KELLER SPRINGS LOFTS

PLANS SUBMITTAL/REVIEW LOG

RFI #: 50
Date: 2/3/2012
Job: EB-02 Keller Springs Lofts
Phone: 877-777-5115

Subject: Sawed dummy joints in paving

PUBLIC WORKS DEPARTMENT	SPACING DIAGRAM FOR TRANSVERSE JOINTS	STANDARD CONSTRUCTION DETAILS PAVING		
		DATE: AUGUST, 2010	REV DATE: -	SHEET: 50-922

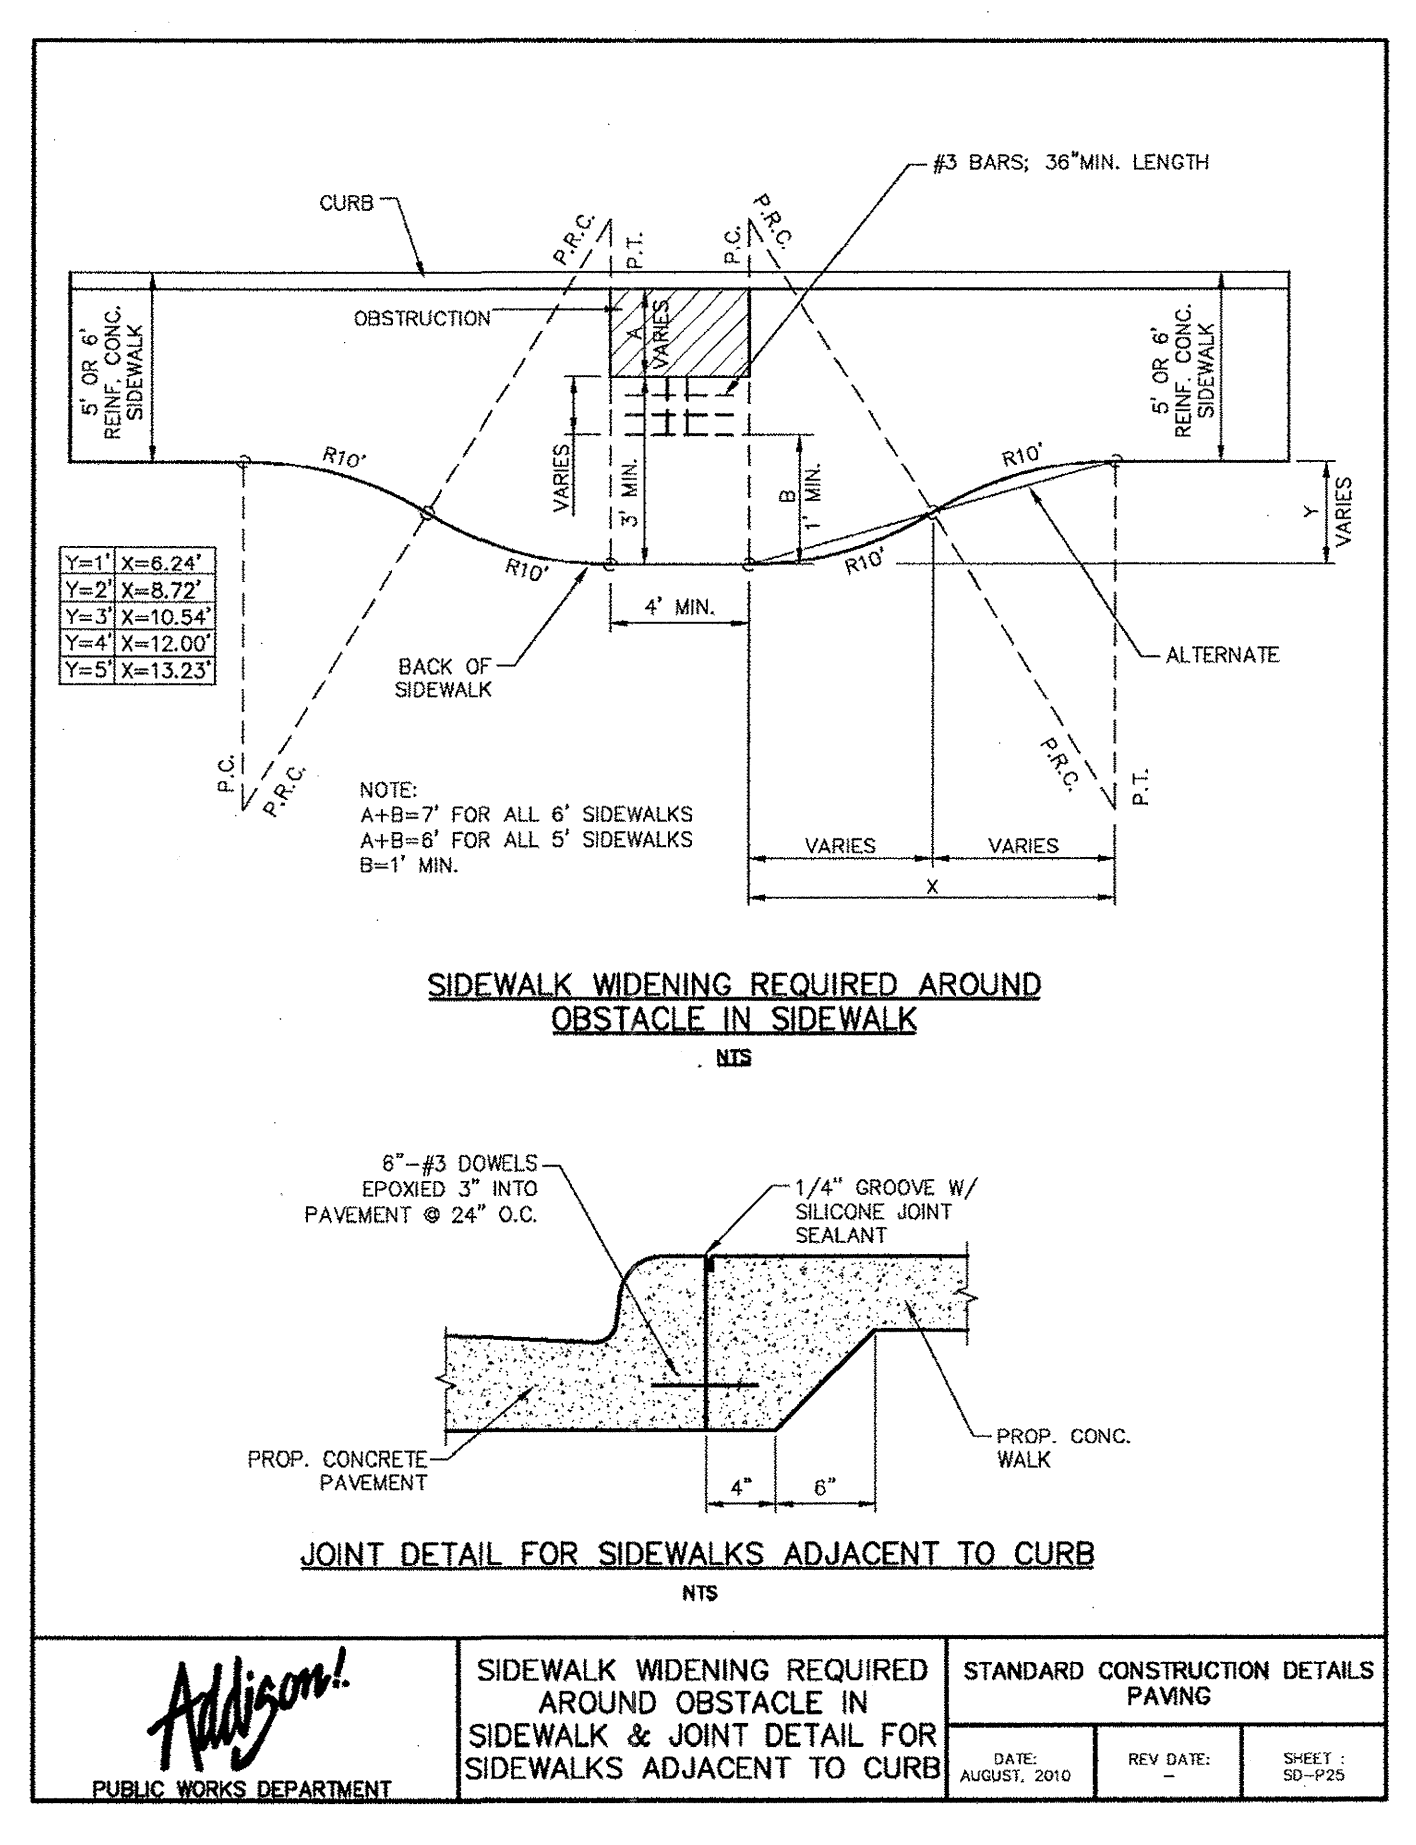
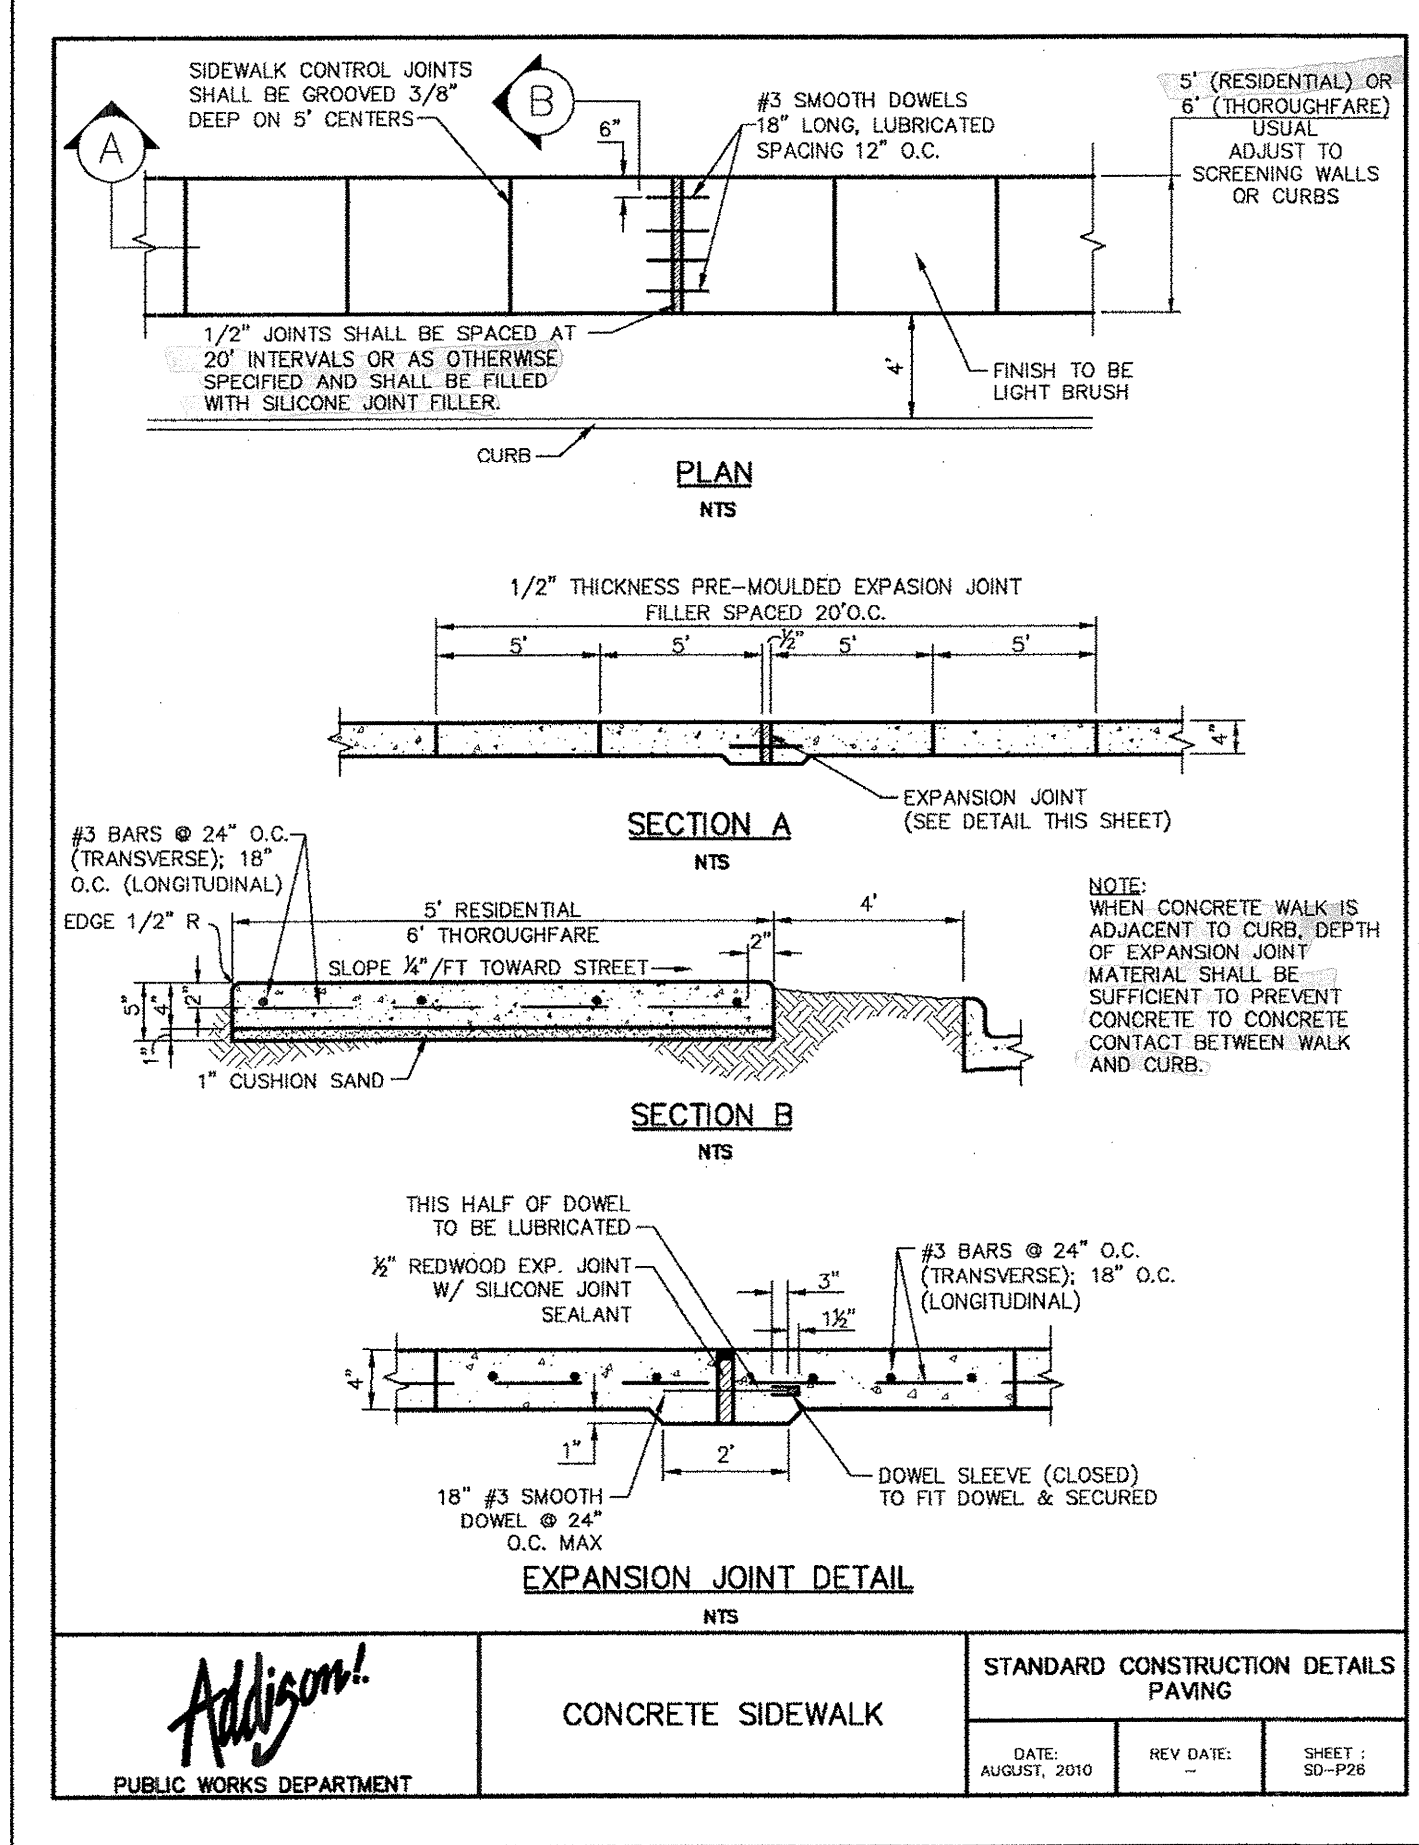
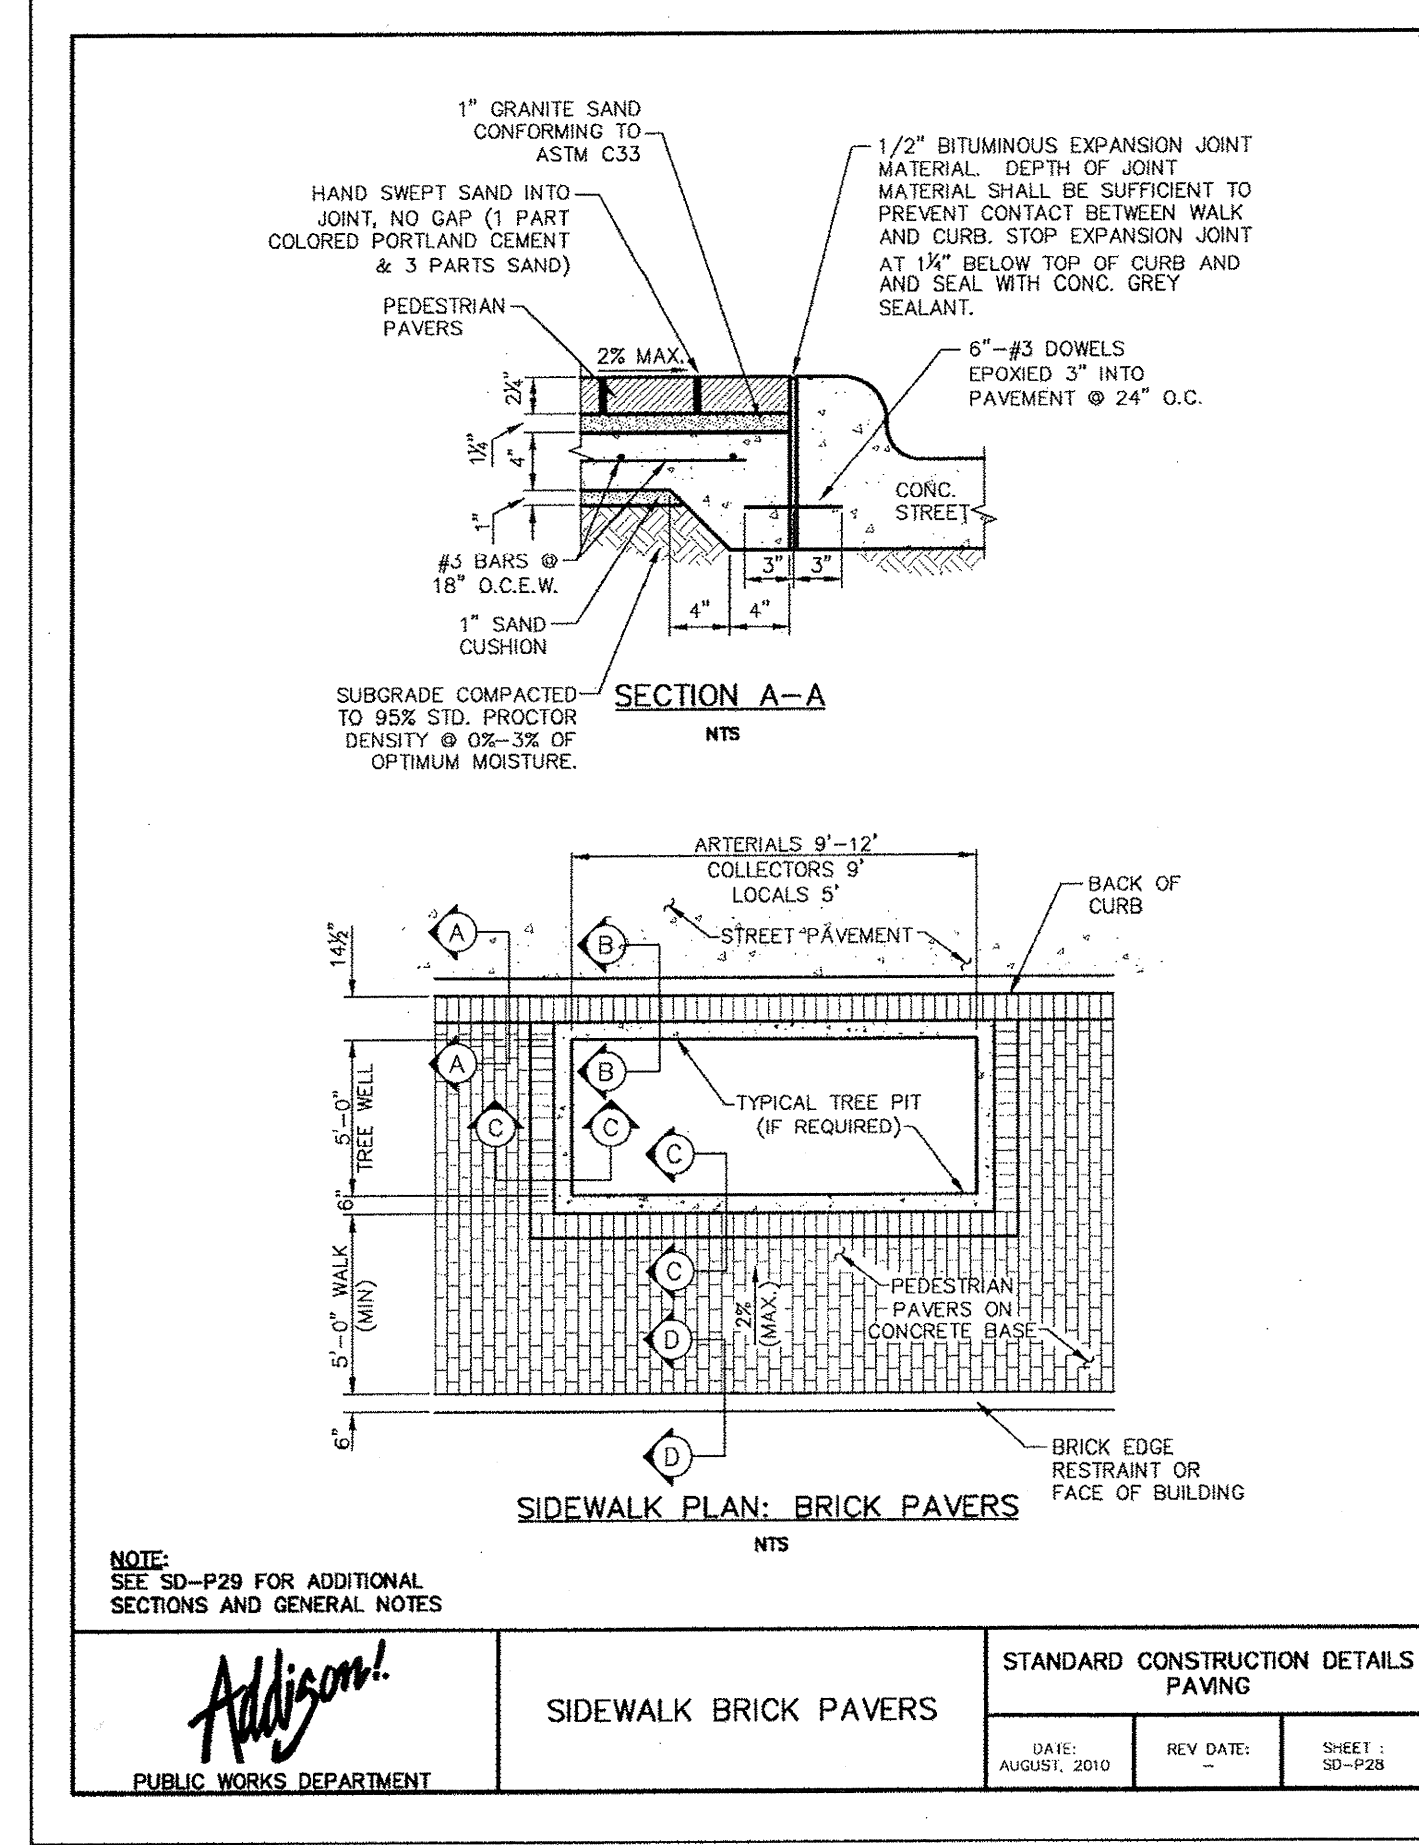
Date Required: 2/3/2012
Request:
On sheet C-02, under paving and striping notes, sentence #8 calls for expansion joints every 150 feet. It also calls for sawed dummy joints every 15 feet in both directions. There is no issue with the expansion joints every 150'. The issue is the sawed dummy joints every 15' both ways. Since most of the drive is only 24', we could split the 24' and put the sawed dummy joints down the middle at every 12'. However, the middle of the drive is also the lowest point of the invert. I don't believe you want a sawed joint at the bottom of the invert. Should we just saw lateral dummy joints and not the longitudinal joints? Or, should the longitudinal dummy joints be offset from the center of the invert? Please advise as we are pouring the first paving on Monday (2-6-2012).

My recommendation is eliminate the longitudinal dummy joints and place transverse dummy joints on 15 foot centers only; also make sure the edge of the fire lane has an expansion joint when abutting other pavement or sidewalk.

I also recommend getting this request reviewed and approved by Dave Wilde with the Town of Addison.
